## **Landscape and Visual Impact Assessment - Review**

**Dean Moor Solar Farm**

**Cumberland Council**

*Issue: Dean Moor Solar Farm LVIA Review\_FINAL\_170625*

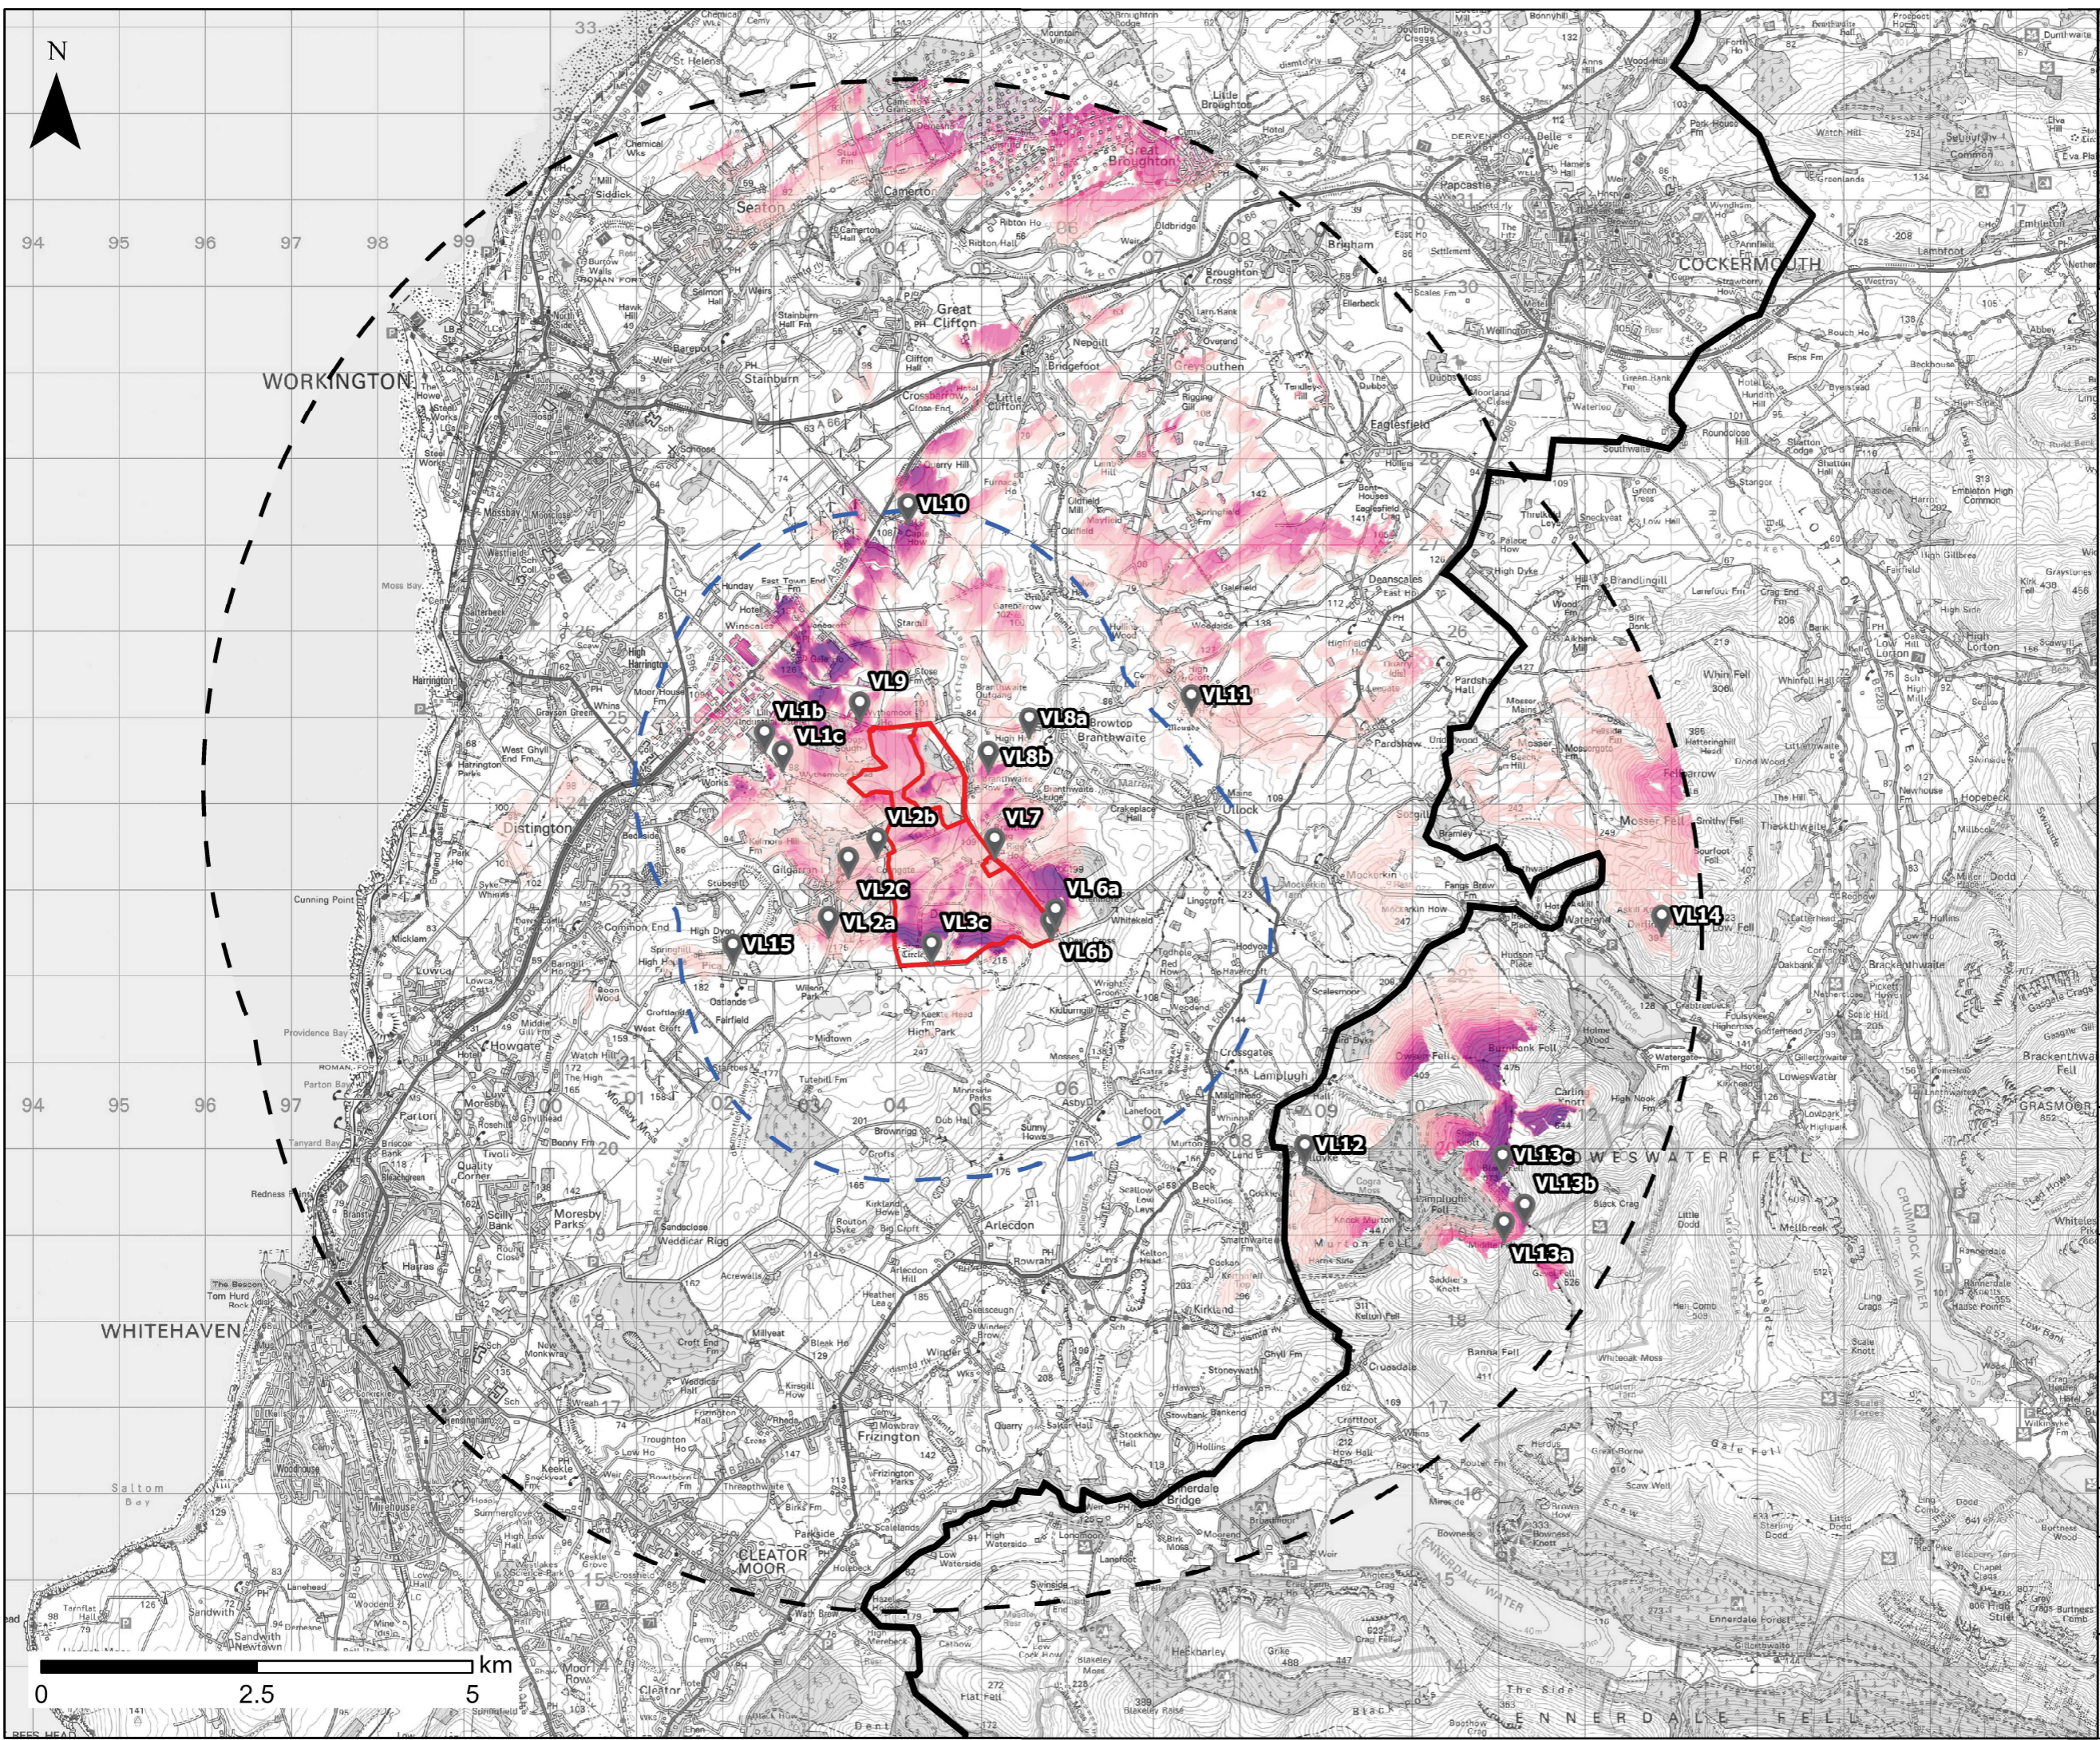
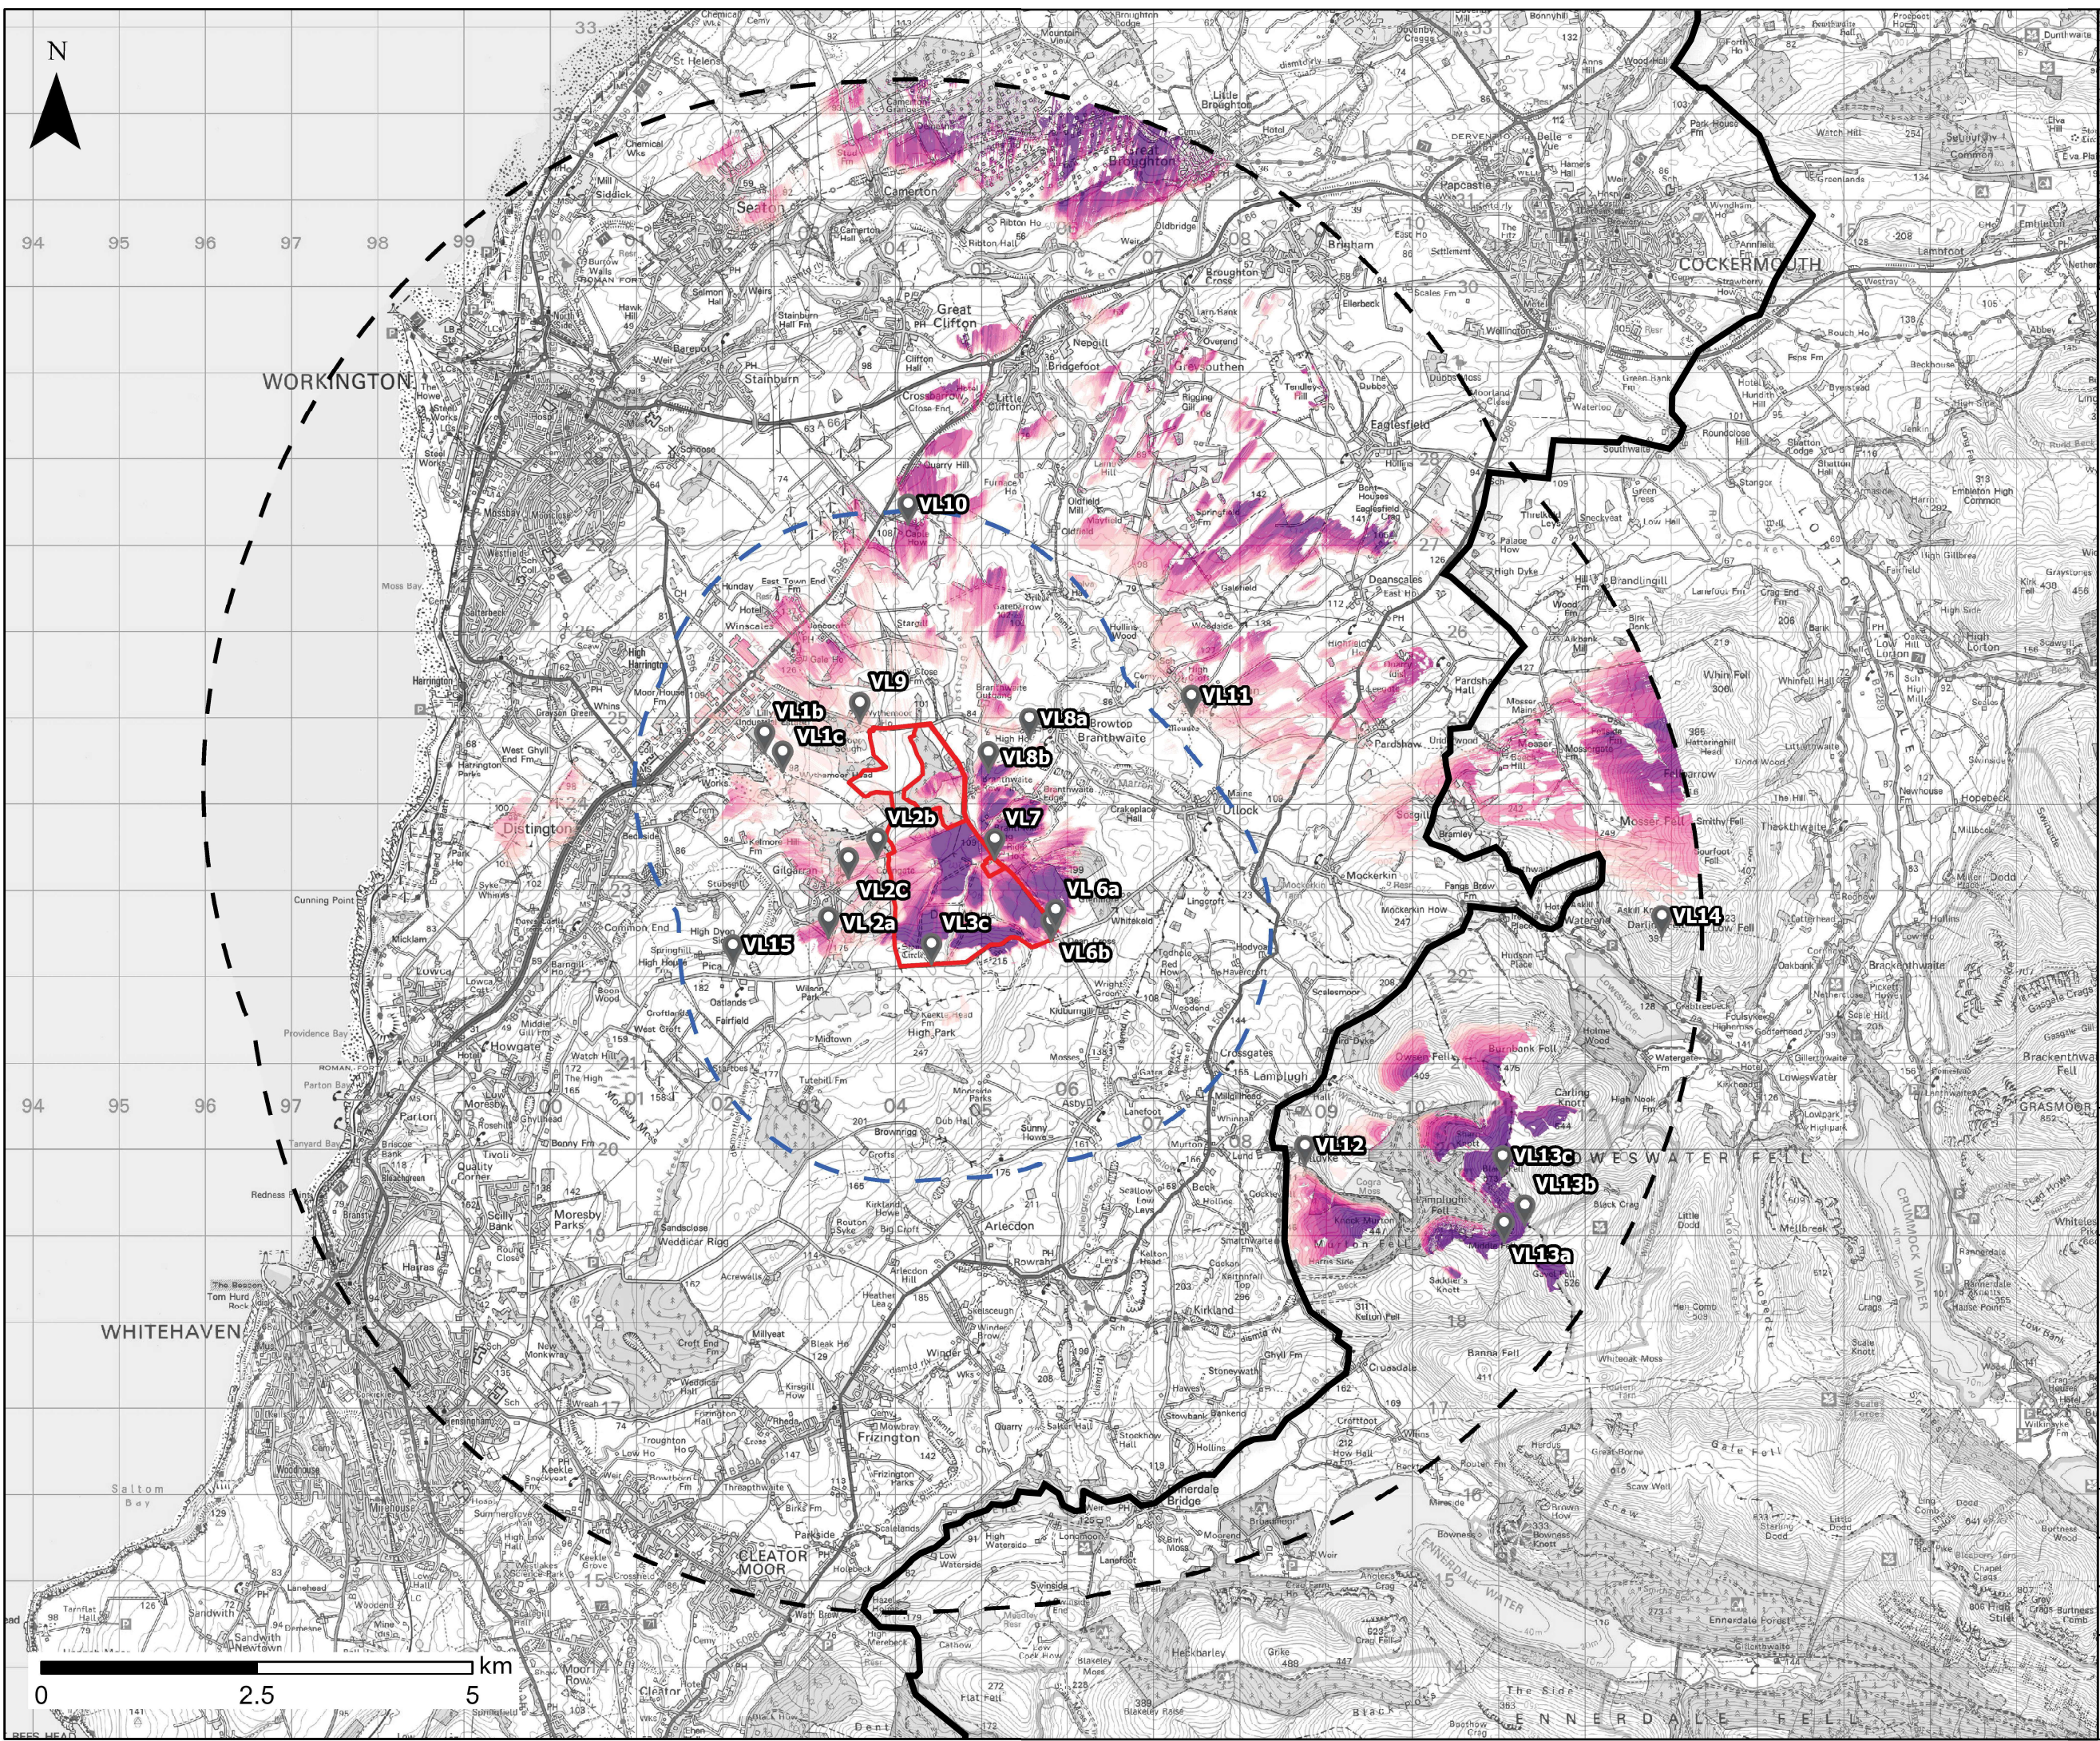
3.3.14	LVIA – Assumptions	<i>'The ES should clearly set out the heights and dimensions of all infrastructure on which the LVIA assessment is based.'</i>	Heights and dimensions of components of the Proposed Development are set out in ES Chapter 3 – Site and Proposed Development Description (Table 3.2). The heights correspond to the heights stated on relevant ZTV plans (Figures 7.4a-b & 7.5a-c).
